## Civil Engineering Statement – Response to Council RFIs

24,26 & 28 Middle Harbour Road, Lindfield

The Proponent has received feedback dated 23<sup>rd</sup> of April 2026 from Ku-ring-gai Council following the submission of the Xavier Knight's civil engineering documentation as part of the EIS submission for the SSD (SSD-82548708).

Rev	Description	Eng	Draft	Date
1	ISSUE FOR DEVELOPMENT APPLICATION	AH	AH	07.05.2025

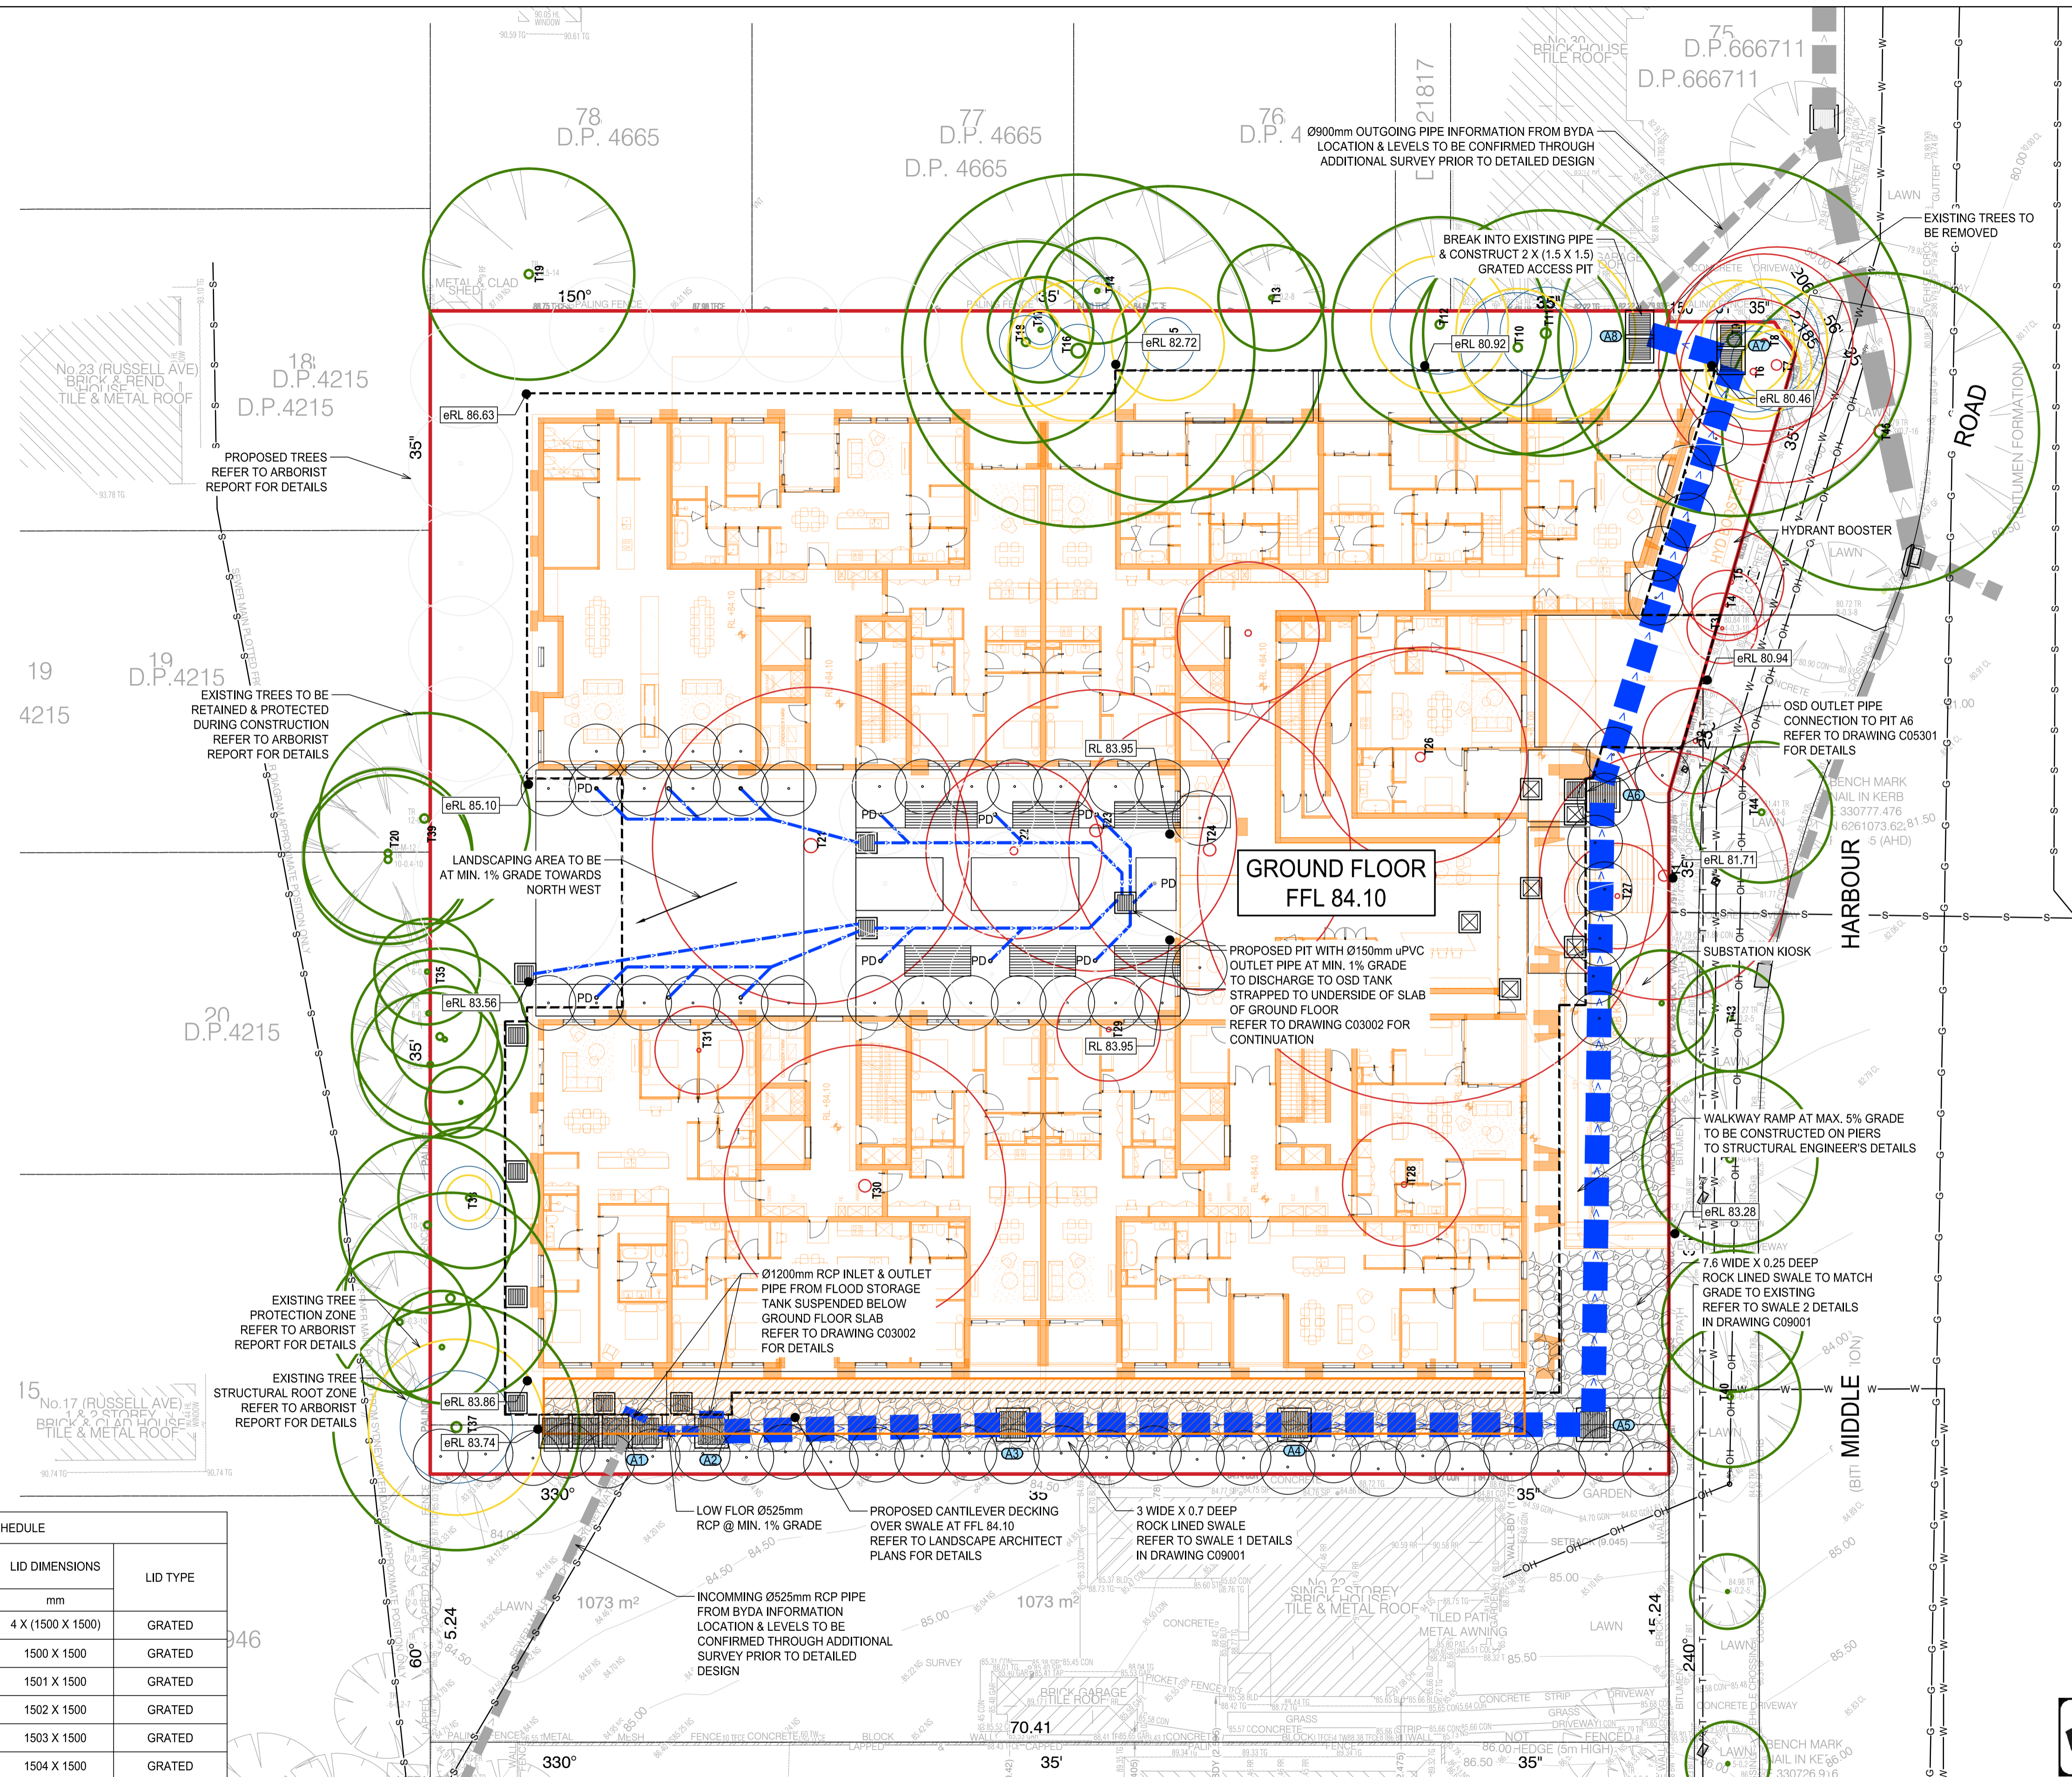
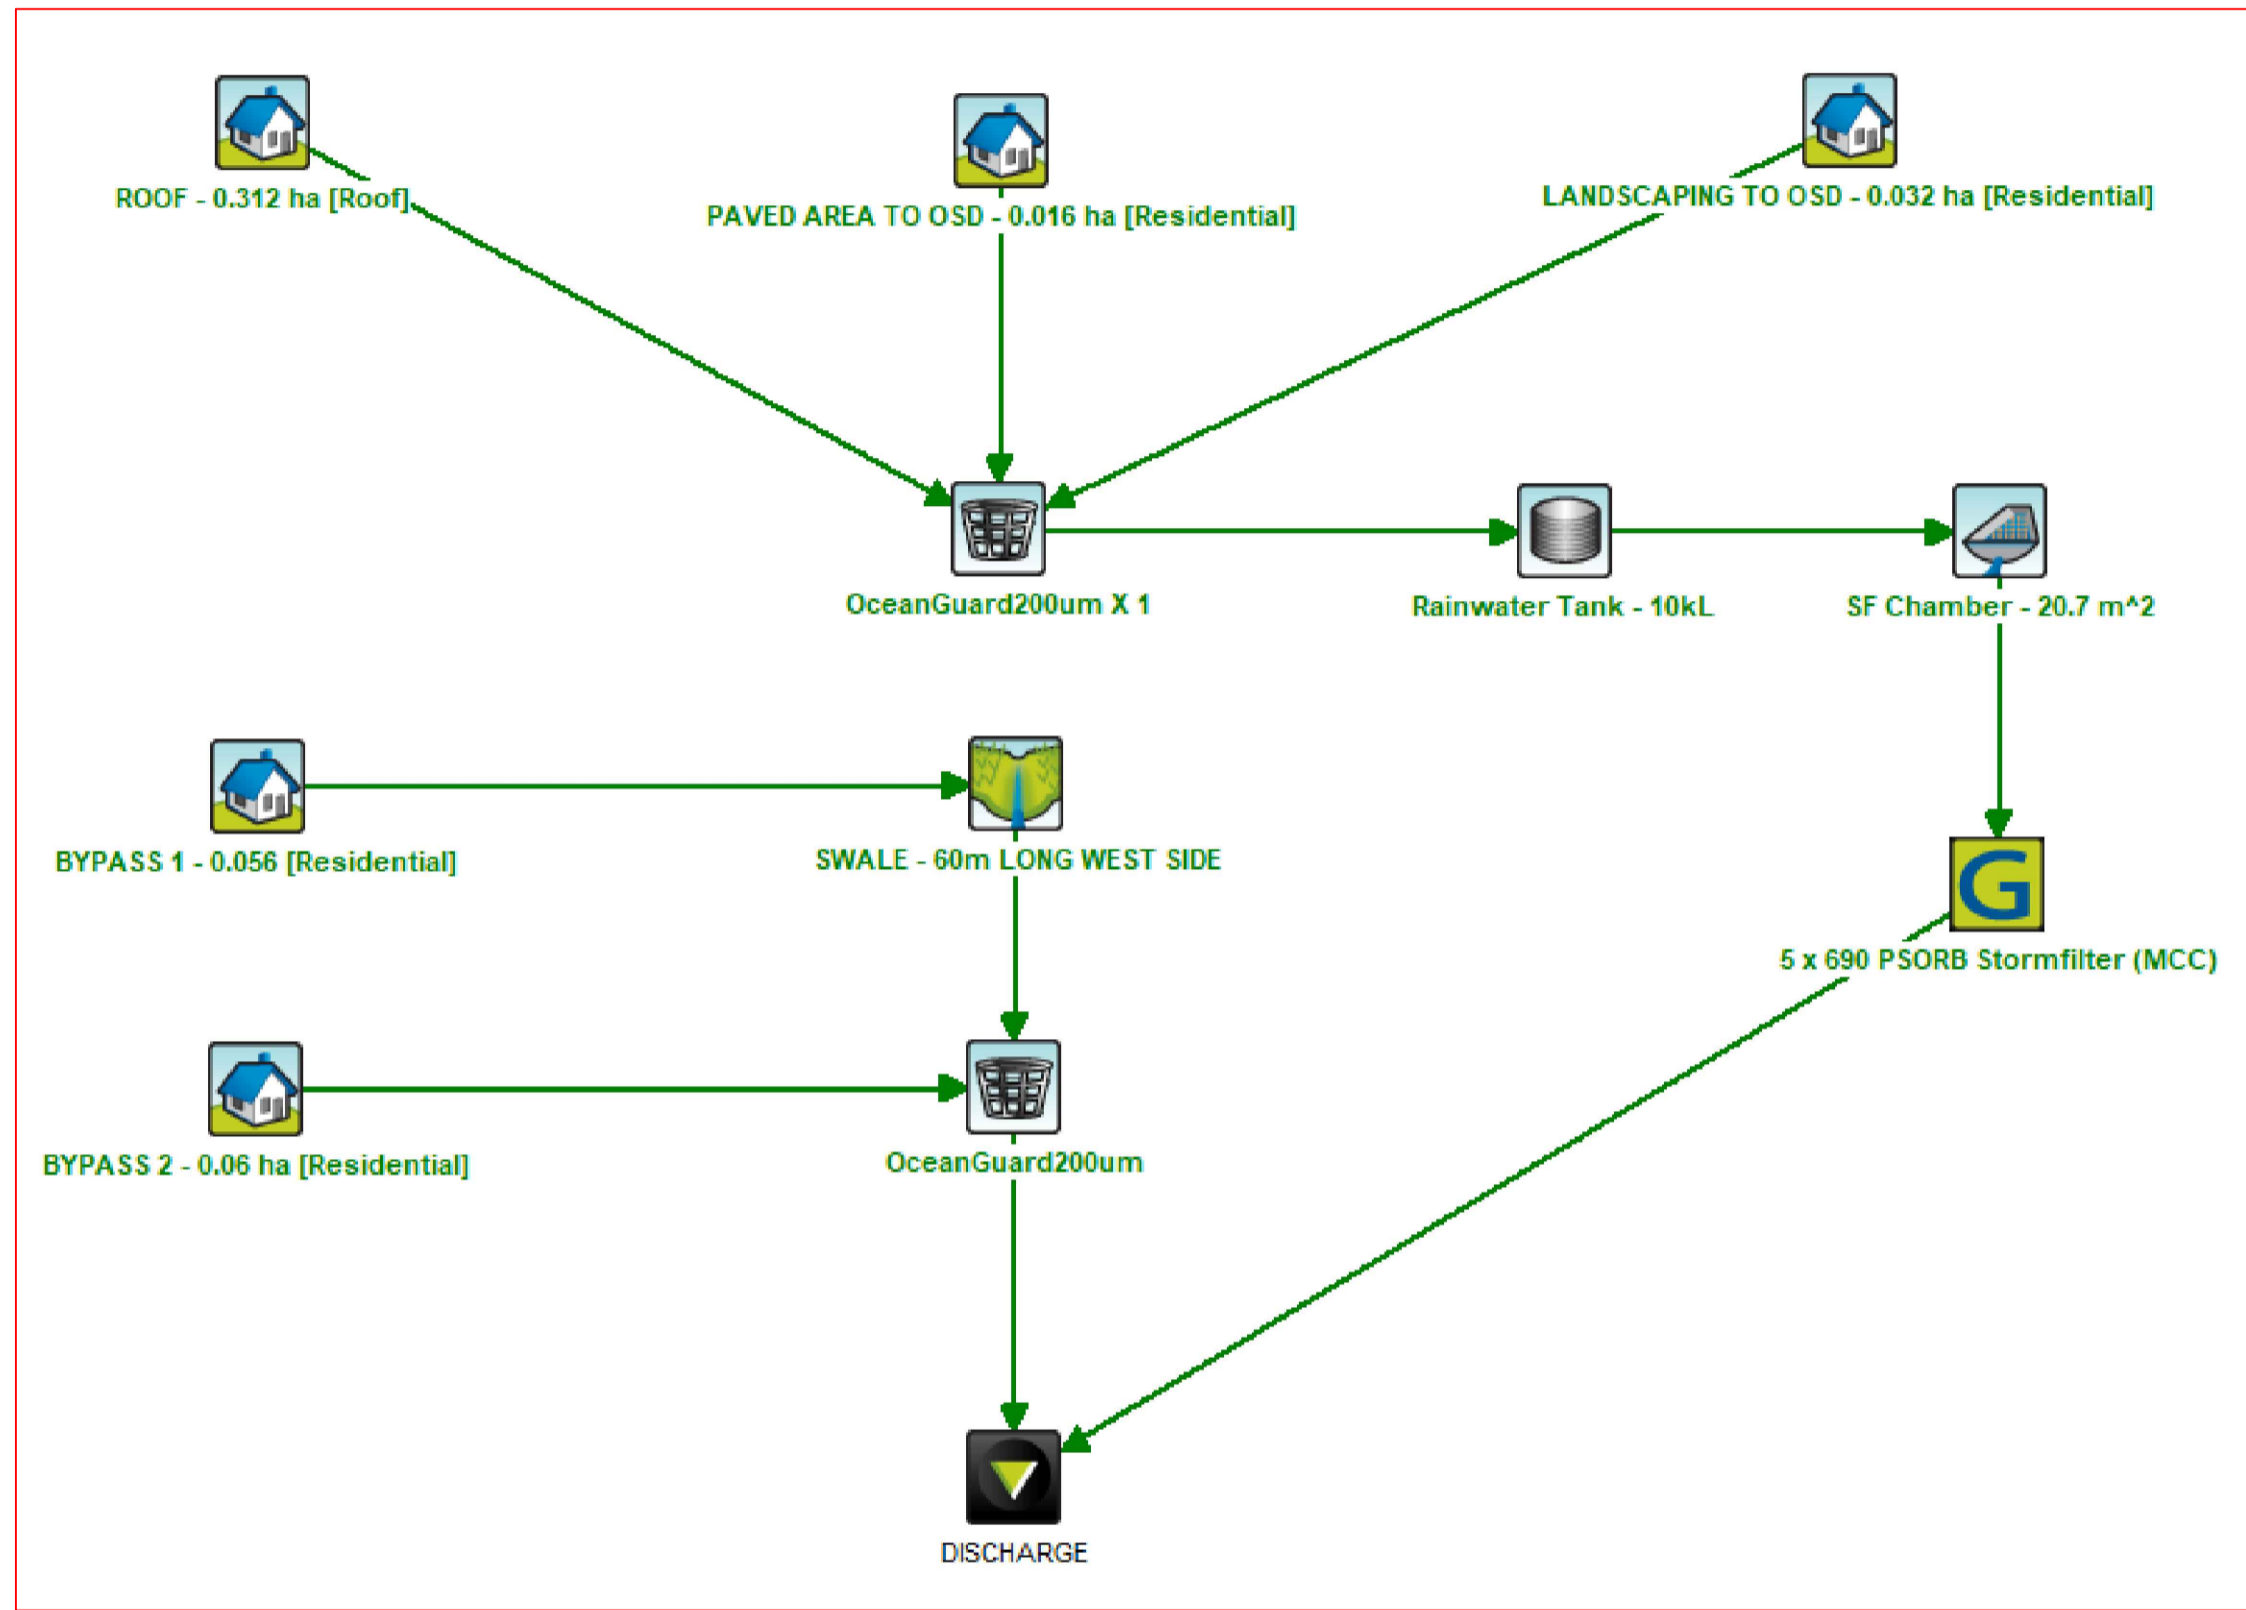
No.	Key Assessment Issue	Response
<b>Civil Plans</b>		
1	Approval from Council's Engineers within the Operations Department is required for the realign/divert Council's existing pit and pipe system. At this stage there is no approval for the works to discharge stormwater and/or realign Council's trunk drainage system.  - The submitted plans do not identify the location or extent of the proposed drainage easement, only the proposed pipeline alignment. (Not Resolved)	Refer to <b>Appendix A</b> of this statement for revised civil engineering plan C03003 showing the extent of a 2.2m wide dedicated easement over the proposed drainage diversion. The width of the easement has been determined in accordance with KDCP Part 24R.2.
2	Council's Operations Team have advised that the proposed trunk drainage diversion/re-alignment cannot be supported given that this design has several deviancies which is considered unacceptable and non-compliant.  Council's Operations Team has previously advised that the proposed trunk drainage diversion/realignment is not supported due to multiple design deviations. (Not resolved)  <u>Key outstanding issues include:</u>	Refer to <b>Appendix A</b> of this statement for revised civil engineering plan C03003 showing 90 degree bends have been replaced with 2 x 45 degree changes in directions.  Refer to <b>Appendix A</b> of this statement for revised civil engineering plan C03003 showing the extent of a 2.2m wide dedicated easement over the proposed drainage diversion. The width of the

No.	Key Assessment Issue	Response
	<ul style="list-style-type: none"> <li>- In the proposal, 90-degree system direction change was proposed. Council does not endorse this type of design. Modification is required to the 90-degree pits.</li> <li>- No details of easement over the proposed drainage system. The width of the easement shall be depicted in accordance with Part 24R.2 of the KDCP.</li> <li>- It is unclear the distance between the proposed building and drainage system. Council requires the proposed building will not be located within "zone of influence" of Council drainage system.</li> <li>- The data provide in "Integrated Water Management Plan" (page 39) "pit 1.4 floods", which indicate that the system could not convey 5% storm event. The detailed calculation is required.</li> <li>- The connections between OSD and Trunk drainage system in the proposal was not clear. Does the OSD have a 1200 mm pipe connection with 1200 mm trunk drainage? Clarification is sought.</li> </ul>	<p>easement has been determined in accordance with KDCP Part 24R.2.</p> <p>Refer to <b>Appendix A</b> of this statement for revised civil engineering plan C03003 which marks the proposed offset from the site boundary and building line. As the shoring wall will transfer building loads into the underlying bedrock, the shoring system will not impose any load on the proposed stormwater arrangement.</p> <p>This is a misinterpretation of the DRAINS data table in Appendix B of the Integrated Water Management Report dated 04.03.2026. For the row with Pit 1.4 information, the label 'FLOOD.S' refers to the connecting modelling node for the 'Flood Storage Tank' which forms part of the 1% AEP stormwater management system. Columns 30 and 31 of the results table show that for Pit 1.4 the peak water levels for the 5% and 1% AEP events are RL81.83 and RL82.25 respectively. These levels are lower than the proposed pit grate level of RL82.92. As such no flooding or surcharging occurs at Pit 1.4</p> <p>Refer to <b>Appendix A</b> of this statement for revised civil engineering plan C03003 showing the 300mm diameter connection from the OSD outlet to the proposed diversion pipe.</p>

3	<p>The proposal seeks to discharge the stormwater runoff created by the new development into Council's existing trunk drainage system which is located within the site. This trunk drainage system traverses diagonally through the property. The applicant has indicated that they wish to realign/divert Council's existing pit and pipe system to cater for the proposal. This cannot be supported in its current format as it is a major burden to Council's infrastructure and long-term</p>	<p>Refer to CCTV footage dated 04.06.2025 of the existing stormwater assets. The footage shows the section traversing the proposed development site is heavily impacted by accumulation of silts, debris and damage from tree roots. The 1200mm pipe size has been selected as it is able to cater for the combined upstream flows from the 450mm and 525mm pipes, while also providing improved capacity to remove runoff</p>

No.	Key Assessment Issue	Response
	<p data-bbox="544 394 1023 454">maintenance, ongoing system failure, deficient pipe sizing etc of the trunk drainage system.</p> <ul data-bbox="544 495 1023 853" style="list-style-type: none"> <li data-bbox="544 495 1023 752">- The applicant proposes increasing the pipe size from 900 mm to 1200 mm. However, the upstream inflows comprise 525 mm and 450 mm pipes, with the downstream connection reverting to a 900 mm pipe. According to the response the downstream and upstream pipe is in good condition, but no supporting reports or any CCTV videos has been provided.</li> <li data-bbox="544 792 1023 853">- No longsections for the drainage drawings have been submitted.</li> </ul>	<p data-bbox="1054 394 1463 454">from the surface which now be instead conveyed by the underground system. Our DRAINS model is able to demonstrate that the connection between the 1200mm pipe and the existing 900mm pipe does not result in any additional ponding or surcharging at the point of connection and there is no impact to upstream or downstream hydraulic performance during the 5% and 1% AEP storm events.</p> <p data-bbox="1054 792 1463 1021">Longitudinal sections with Hydraulic Grade Line analysis have been provided in Section 3.8 of the Integrated Water Management Plan report. A detailed longitudinal section will be prepared as part of the Design Development phase of the project.</p>
